WEST SUSSEX COUNTY COUNCIL CONSULTATION

TO:	Arun District Council FAO: Juan Baeza
FROM:	WSCC - Highways Authority
DATE:	12 April 2019
LOCATION:	60 Vermont Drive Littlehampton BN16 1LG
SUBJECT:	EP/43/19/DOC Approval of details reserved by condition imposed under ref EP/69/17/PL relating to Condition No 8 cycle parking spaces.
RECOMMENDATION:	Advice
S106 CONTRIBUTION TOTAL:	£N/A

LOCATION OF PROPOSED
BIKE SHED

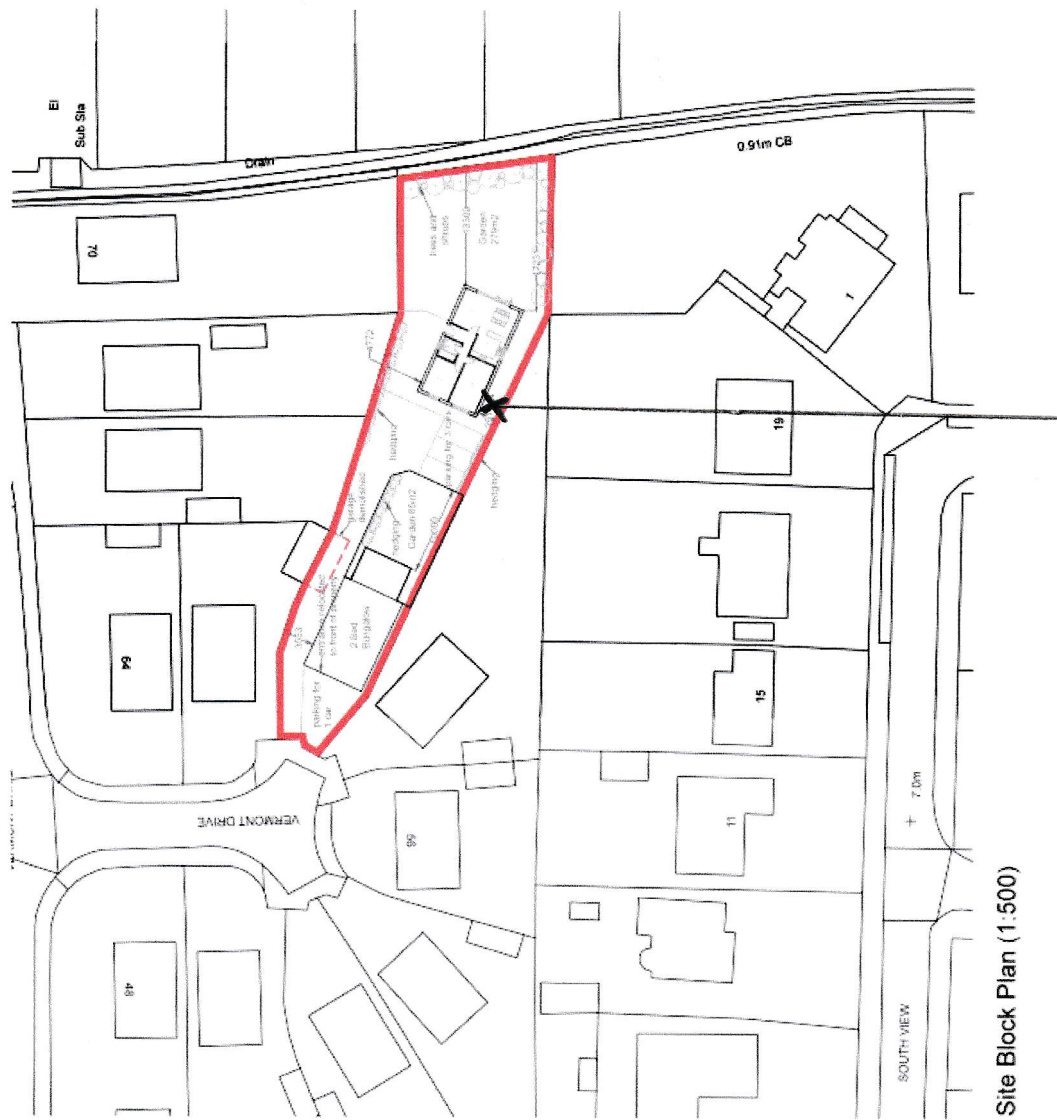
The plans indicate that the covered and secure bicycle storage will be provided within the plot for the new dwelling.

The plans and details pertaining to condition 8 are acceptable.
